Planning Division Memorandum

RE: 72 Walnut Street (duplex)
Shopov Residence
Final Design Review Comments (Administrative Review)

NOTE OF CONCLUSIONS FROM DESIGN REVIEW MEETINGS

FRONT ELEVATION

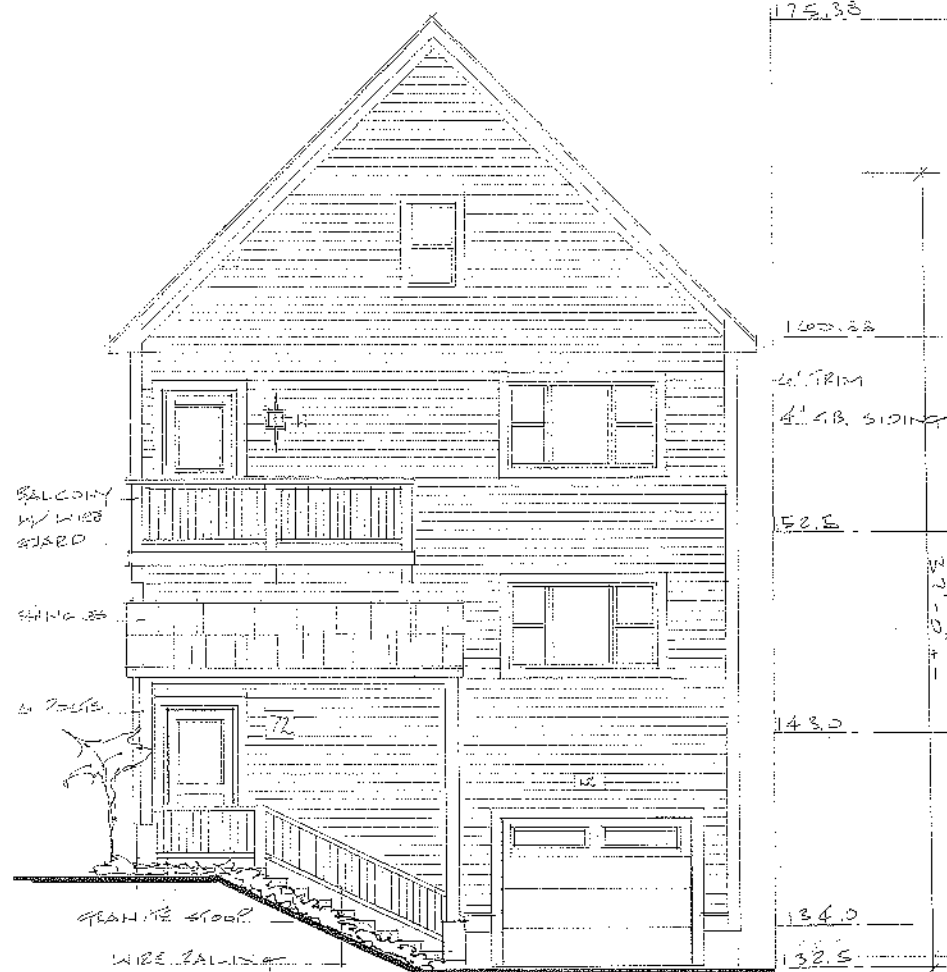
- *The main entrance is on the side of the building, rather than oriented to the street, and therefore the project does not meet Standards A-2, A-3, C-1, and F-6. The Design Standards (Section C and F-6) do suggest ways that this standard may be met while retaining the side entrance ie by linking it to a front door that faces directly onto Walnut Street (and that meets the design standards).*
- *Please provide a sidewalk profile so that the proposal may be assessed in relation to the Standard C-2.*
- *Please clarify the proposed materials for all elements of the structure, including details and material of the porches so that the proposal may be assessed in relation to Standards in Sections F and G.*

- *The revised building addresses most of the issues raised in relation to the earlier submissions. The main outstanding issue is the fenestration on the front elevation which does not meet Standards D-1, F-2, and G-4. As discussed, the two kitchen windows need to be revised and another window should be introduced over the porch, either to align with the main entrance door or centered on the porch roof.*
- *Thank you for the samples of materials, which are acceptable. Please specify on the plans (we do not need to see samples) the porch and balcony finishing details.*

The final plans (received June 12, 2009) provided the remaining few details, introduced another door over the porch, and revised the windows on the front elevation (similar to those on the other elevations; also balanced and stacked within the front elevation). The final plans also address Deb Andrews (HP) request that the doors on the front elevation have glazing bars and that the porch supports be reduced in scale.

Staff did not find any benefits associated with the alternative front elevation (submitted at the same time), so Plan A1 (dated 4.20.09 rev.6.7.09) is the basis for this final review. Staff considers that, with the revisions made by the applicant over the last few months, the proposals in the 6.7.09 Plan Set now meet the *Design Principles and Standards*.
